Application by Highways England for an Order granting Development Consent for the M25 Junction 28 Improvements scheme

Written Representation submitted on behalf of Luddington Golf Ltd.

Planning Inspectorate Reference No: TR010029

Impact Assessment of The Proposed M25, Junction 28 Improvements On Maylands Golf & Country Club

**Golf Accommodation Works Key**

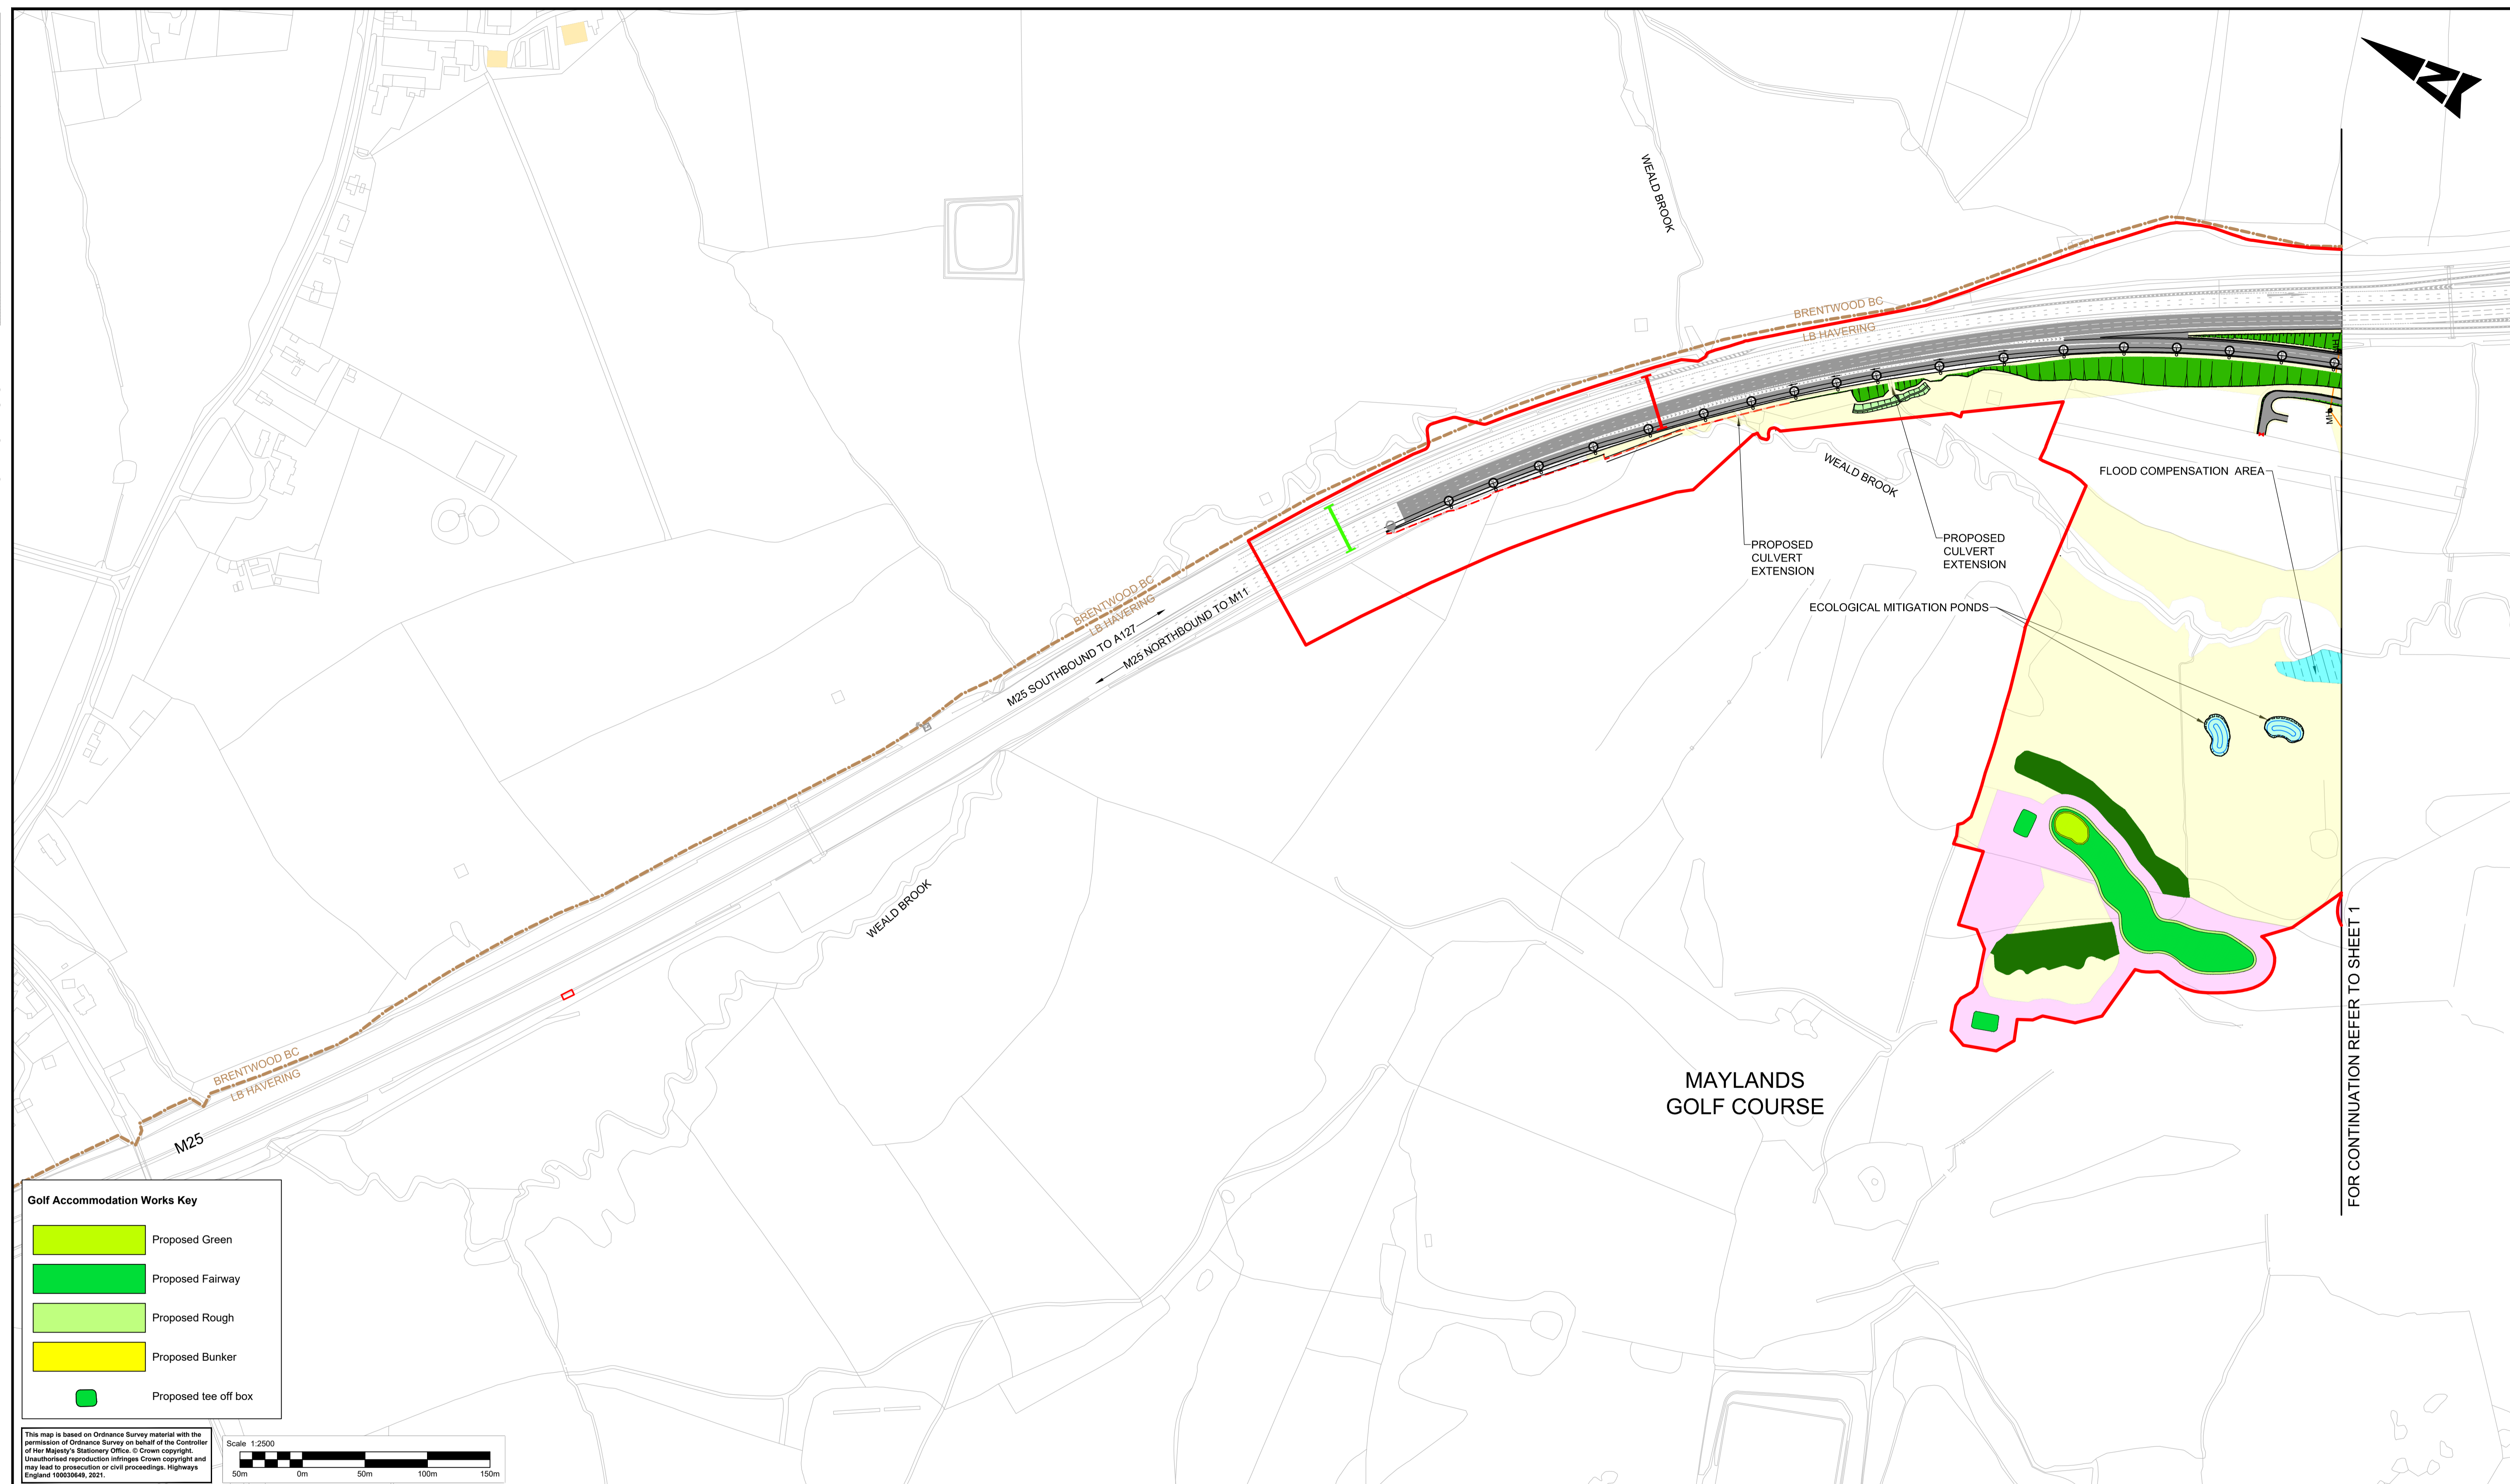
3.4 In order to both try to avoid restricting the speed of play and create a safer route to Hole 3, the Applicant proposes that a 'boardwalk' combined with a gravel path is to be created as a way of enabling golfers to take a somewhat shorter route between the green of Hole 2 and the teeing ground of Hole 3. But the Applicant's Solution routes both through the recognised protection zone of the colony of Great Crested Newts; the gravel path being on firm ground whilst the boardwalk is a raised structure that bridges over the newt pond.

3.5 LGL has not been provided with any detailed drawings of the boardwalk but its understanding is that this will be a wooden structure, obviously raised above the prevailing ground level in order to bridge the newt pond. It will have to be a structure of some substance as not only must it carry the weight of a group of four golfers each with their golf trolley to carry their clubs passing along it, but must also be sturdy enough to support the weight of potentially two 'golf buggies'; these being the electric vehicles each designed to carry two seated golfers and their equipment and a facility favoured by many older players. In discussion, the Applicant has indicated that the boardwalk will be wide enough to enable two golf buggies to pass each other safely so we are talking of something some 3 metres in width and for safety purposes it will have to have side barriers to prevent golfers and/or a golf buggy slipping off the edge and into the pond. All of which will represent an additional maintenance liability for Maylands.

- 3.7 The Applicant's Solution uses the boardwalk as a means of reducing the unacceptably lengthy walking distance between the two golf holes in question created by the Applicant's adherence to its view of how the 'lost' Hole 2 should be reinstated. But LGL considers it not unreasonable to comment that if the roles were reversed and it was Maylands rather than the Applicant that was putting forward a proposal to encroach into a protected zone by the construction of such a structure with its likely need for further intrusion into the protection zone for regular maintenance, any such proposal by Maylands would be vetoed immediately on environmental grounds.
